**IVANHOE ESTATE STAGE 1 – LOT A1 & C1
MACQUARIE PARK NSW**

ACCESS REVIEW

FINAL V.2

29th Nov 2018

Building A1
Ivanhoe Estate, Macquarie Park
Lower Ground Plan

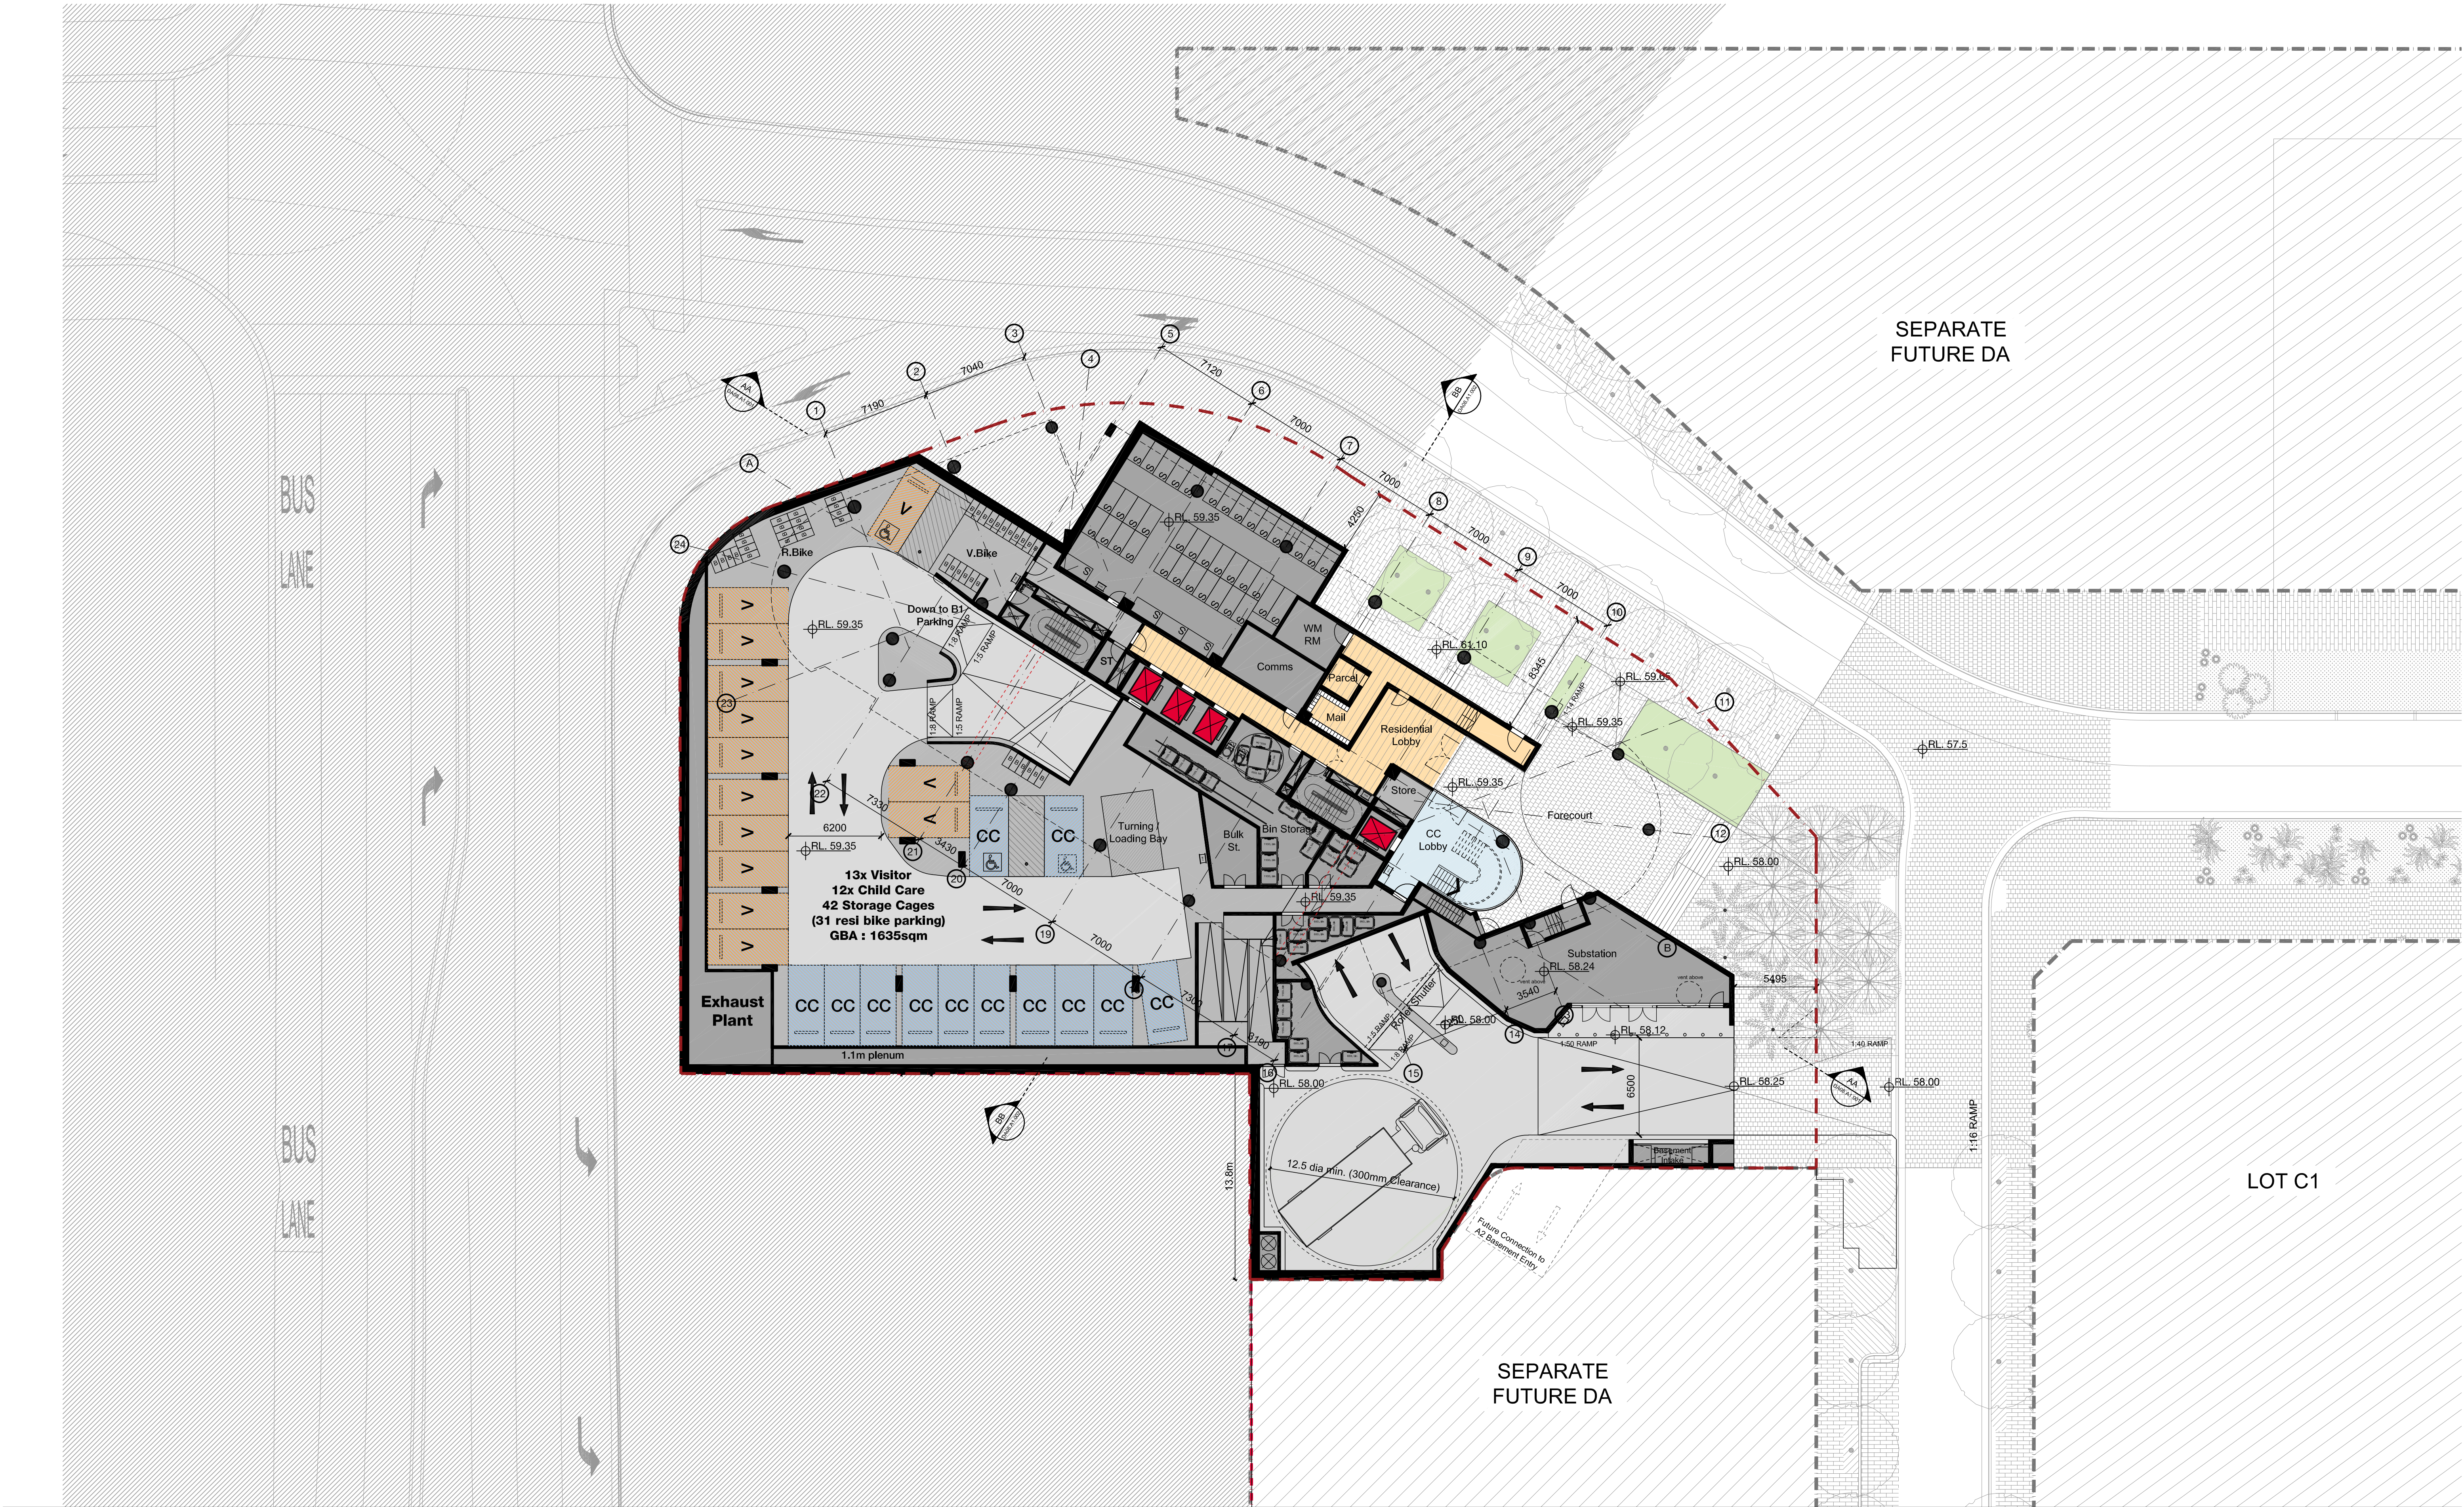
From south-east lot boundary, pedestrian access to the building entrances is via wide stairs that lead to the 'Forecourt' that connects to the 'Residential Lobby, lower ground level. Accessible path of travel is via a 1:14 ramp that has compliant space to accommodate appropriate TGSIs & handrails. This will be developed further at DD stage.

There is an alternate entry access to the building via the Mail Room from lower ground level Forecourt. This is not accessible due to the path of travel being via series of external stairs, however an alternate entry is available from inside Residential Lobby.

- (i) Provide directional signage at external stairs to alternate building entrance, lower ground level via Mail Room identifying the accessible main entrance.
- (ii) Short set of stairs neighbouring the main entrance and external entry stairs to be suitably set-back at least 650mm (900mm min. preferred) from the walls & landscape so required access features (handrail extensions and TGSIs) can be provided without protruding onto traverse path of travel, compliant with AS1428.1.

The main entrance to the Lot A1 Childcare Centre (CC) tenancy is located at southern side of building at lower ground level. Access to CC tenancy is from the same ‘Forecourt’ as ‘Residential Lobby’ at lower ground level described above and shares the same requirements for an accessible path of travel.

- (i) Ensure main entry doors have light weight operation to assist wheelchair users. To comply, the door shall have an operative force of no greater than 20N.
- (ii) Ensure the CC entry lobby stair has suitable set-back at least 650mm at base, 400mm at top (900mm min. preferred at base) from adjacent wall so required access features (handrail extensions on both sides and TGSIs) can be provided without protruding onto traverse path of travel, compliant with AS1428.1.
